CITY OF ALBUQUERQUE

**Re: Enterprise-Rent-A-Car
3500 Coors Blvd NW
30-Day Temporary Certificate of Occupancy
Transportation Development Final Inspection**
Engineer's/Architect's Stamp dated 02-14-19 (G11D058)
Certification dated 4-30-19

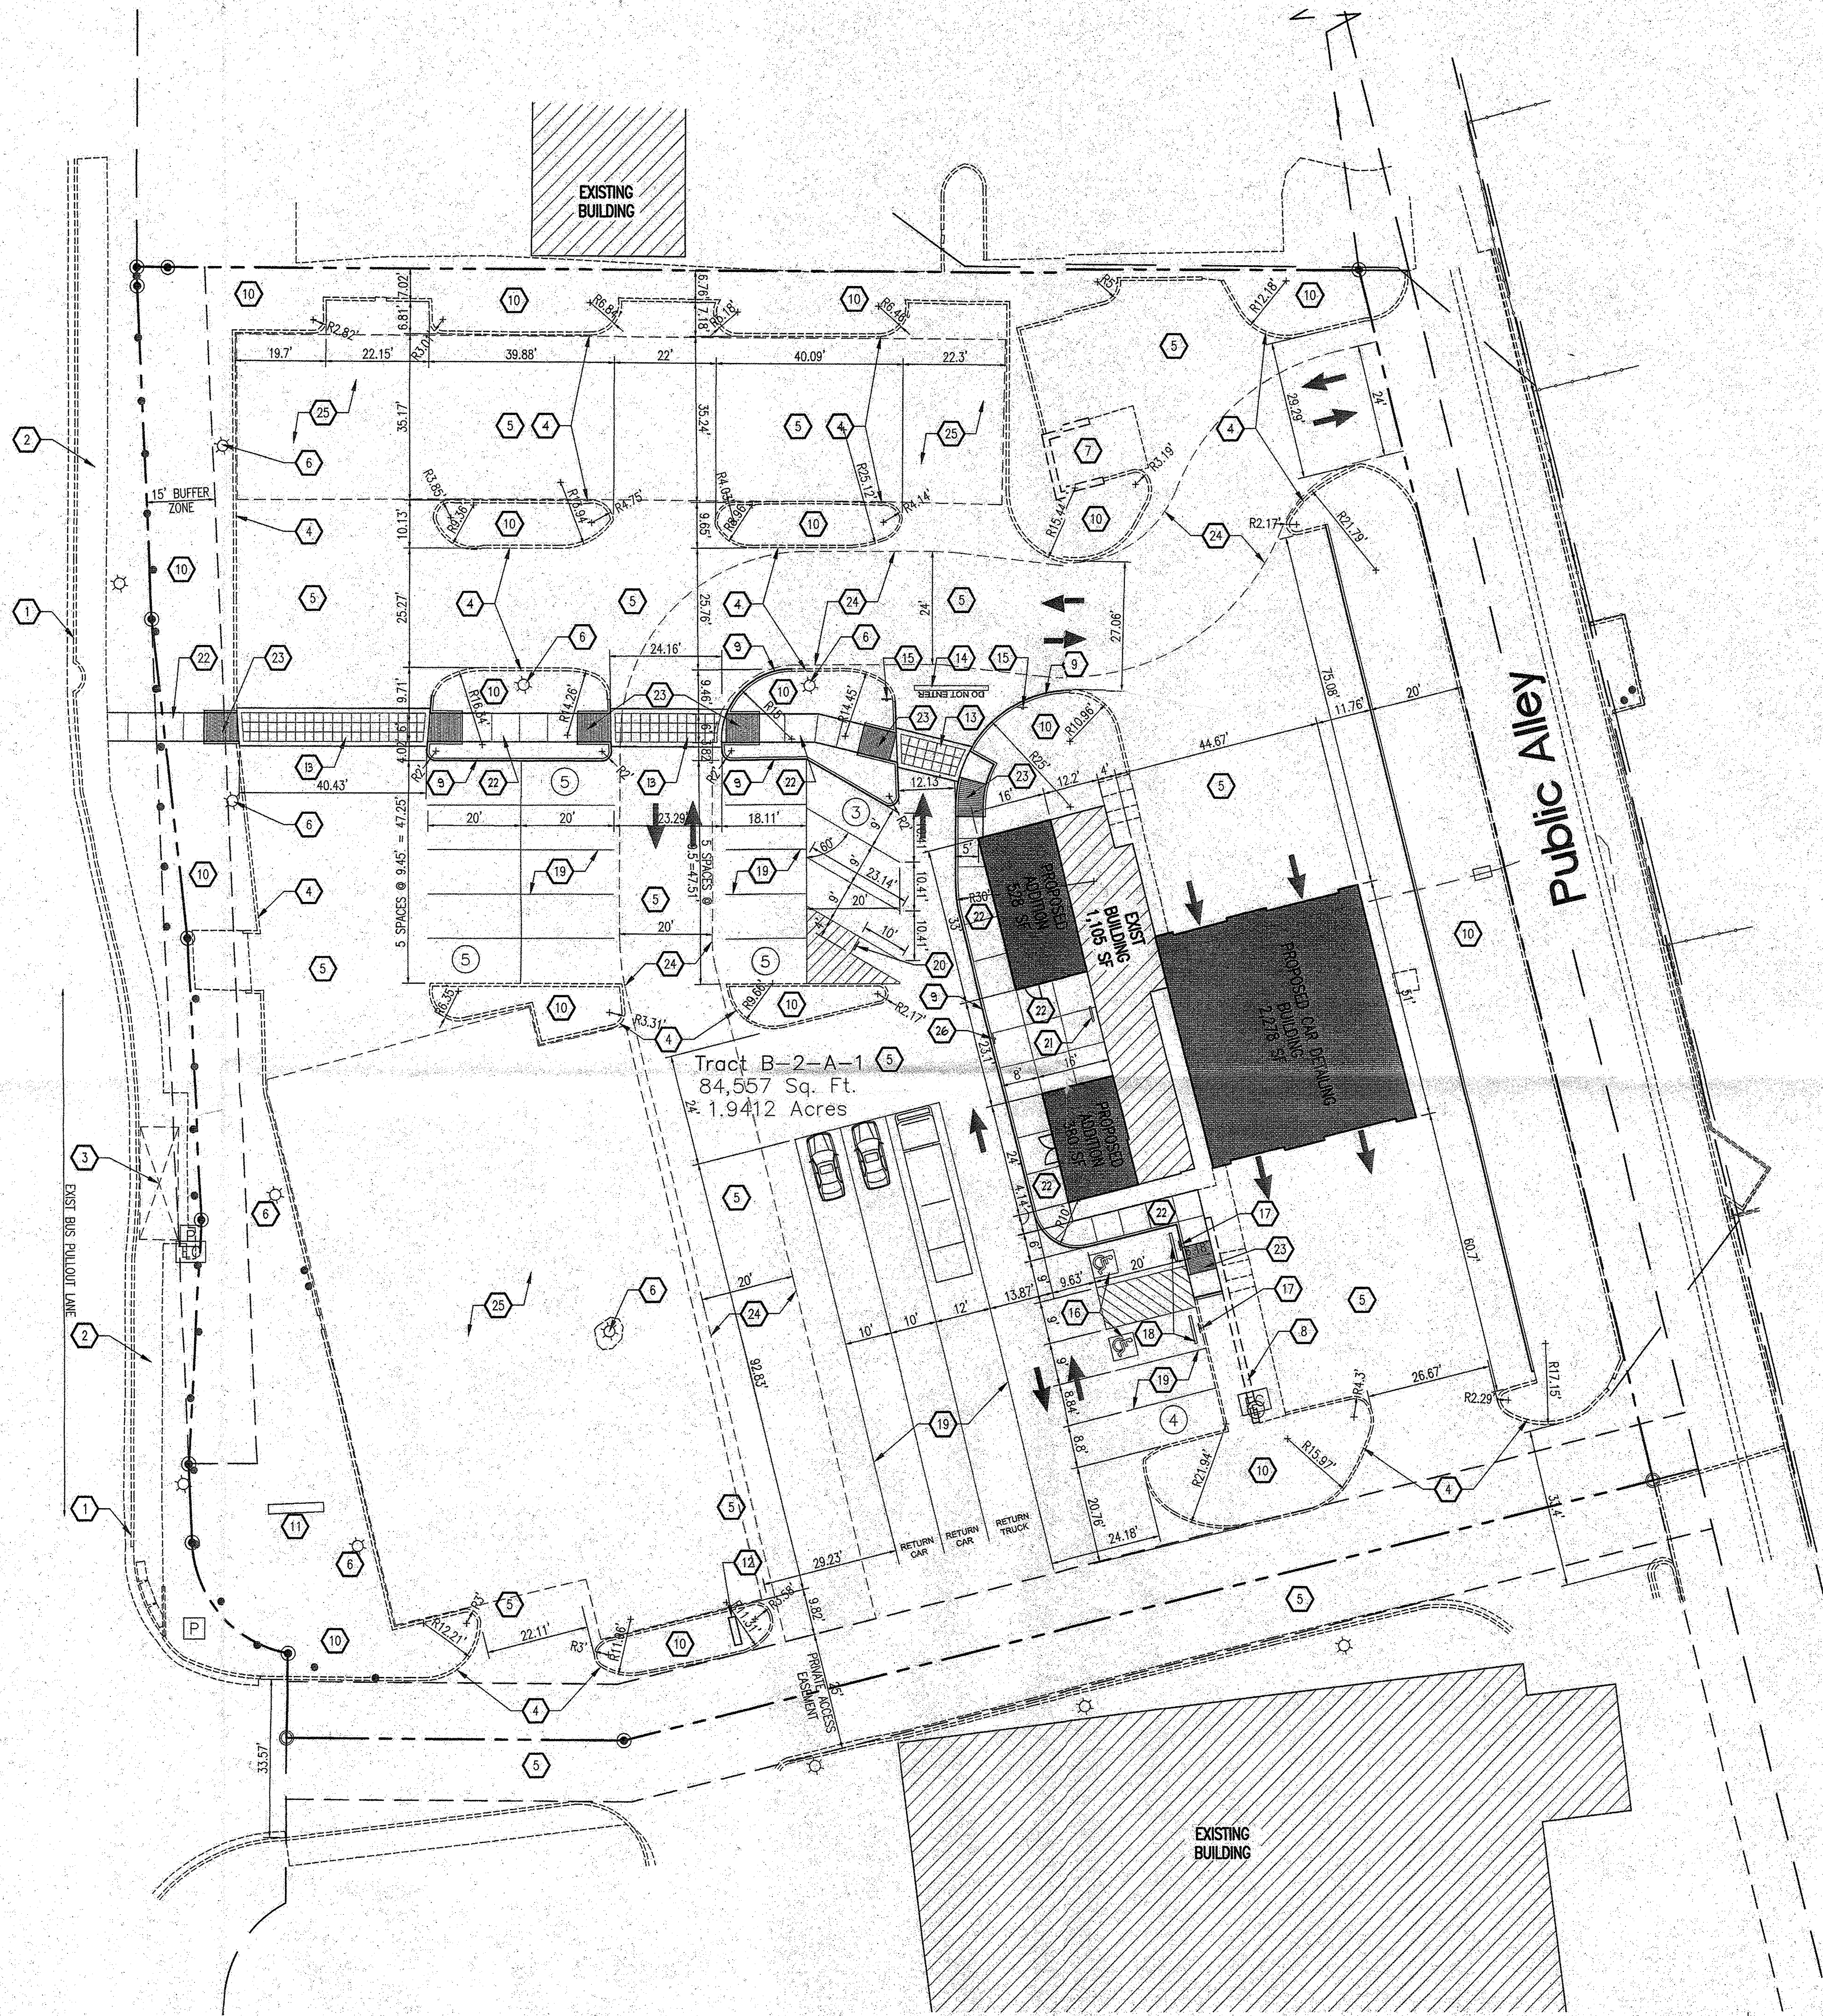
1. Please add missing directional sign. Keynote #26 "One Way" Traffic Sign.
2. Please remove construction equipment, porta potty, orange cones and yellow tape.
3. Please send photos of corrections for release of final CO
